KITTITAS COUNTY COMMUNITY DEVELOPMENT SERVICES

July 31, 2019

RE: Marian Meadows Development Agreement (DV-19-00001) – Transmittal of Comments

RV Illustration 1

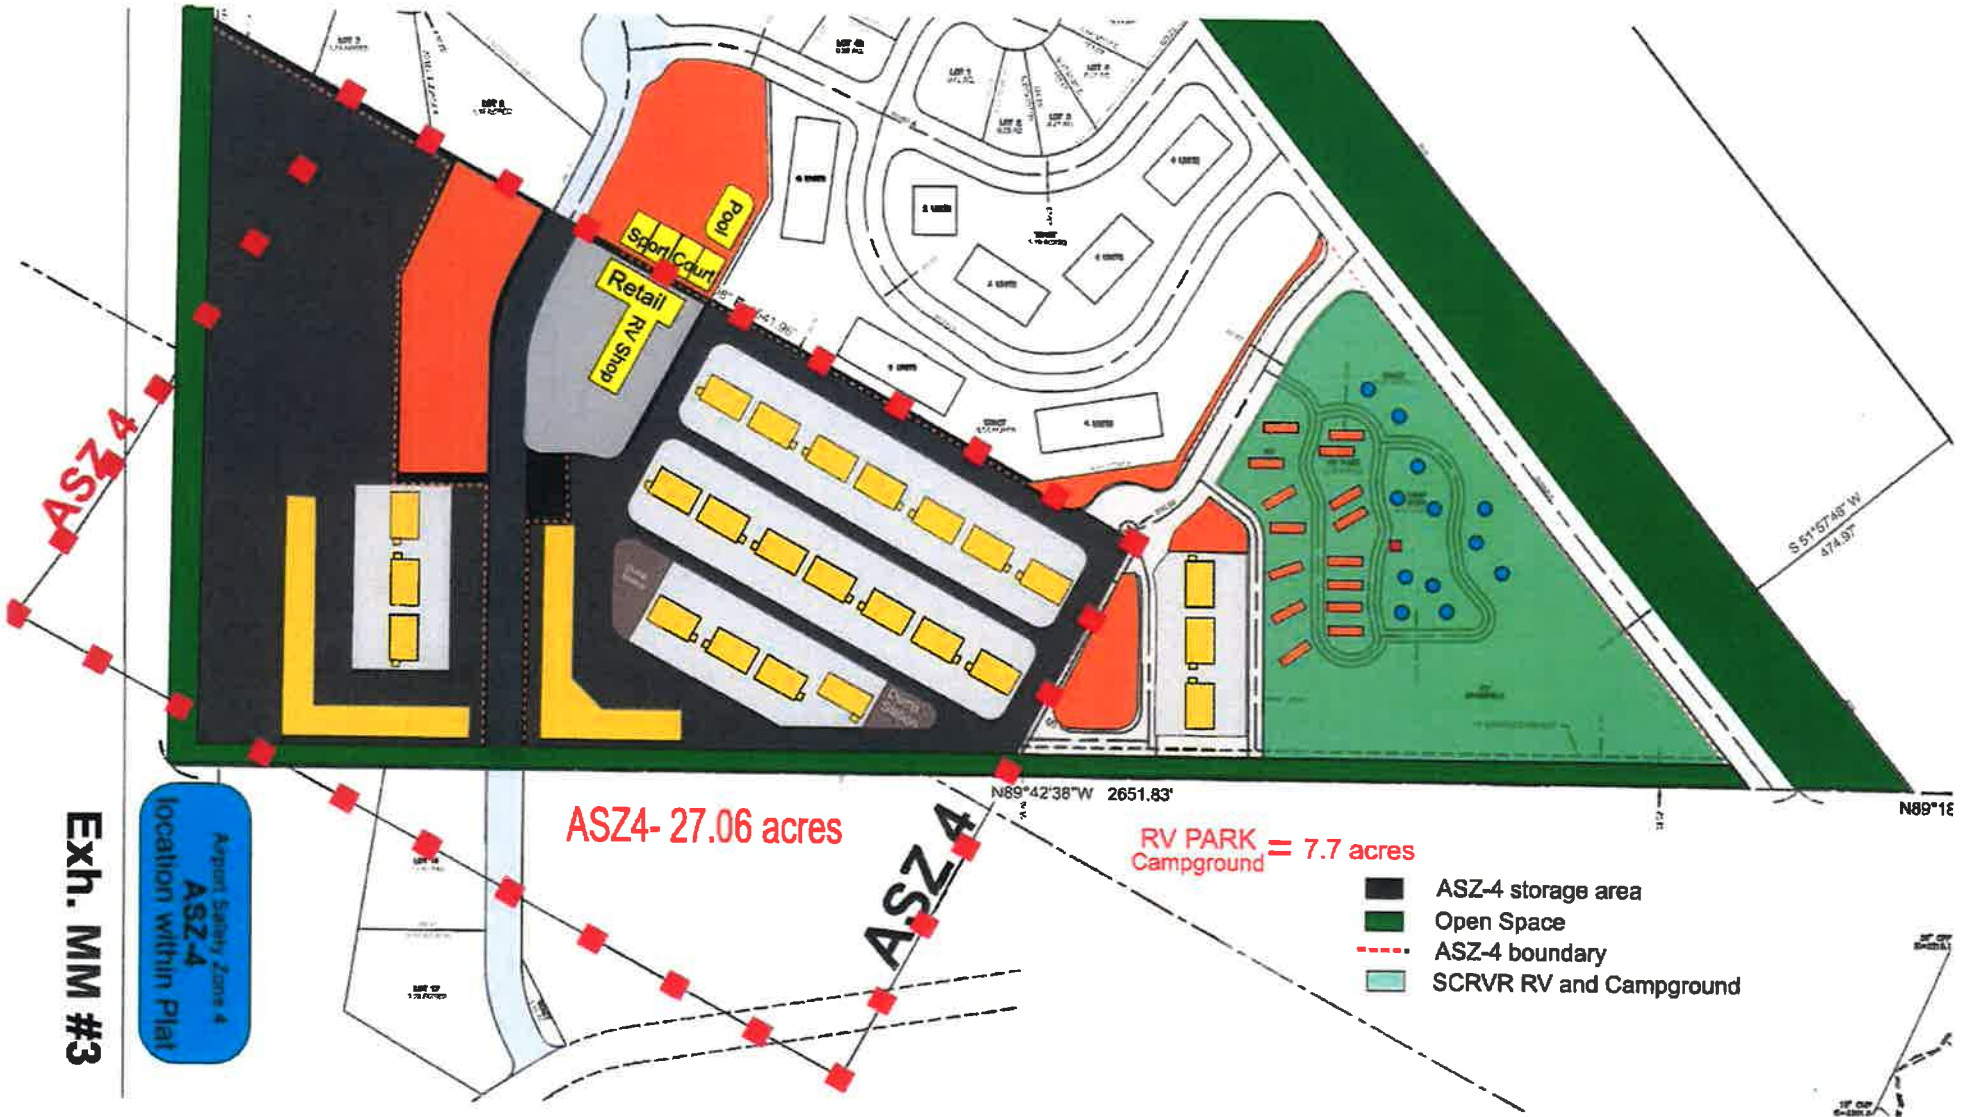
1. Specify the quantity of campsites and RV sites.
2. Identify access to Lot 19 on the RV layout illustration.
3. Pursuant to Ordinance No. 2018-006, Public Works' condition of approval 11.3.9 requires a right-of-way (ROW) with sufficient width to allow for the storage of snow within that space without impacting the travel lanes.
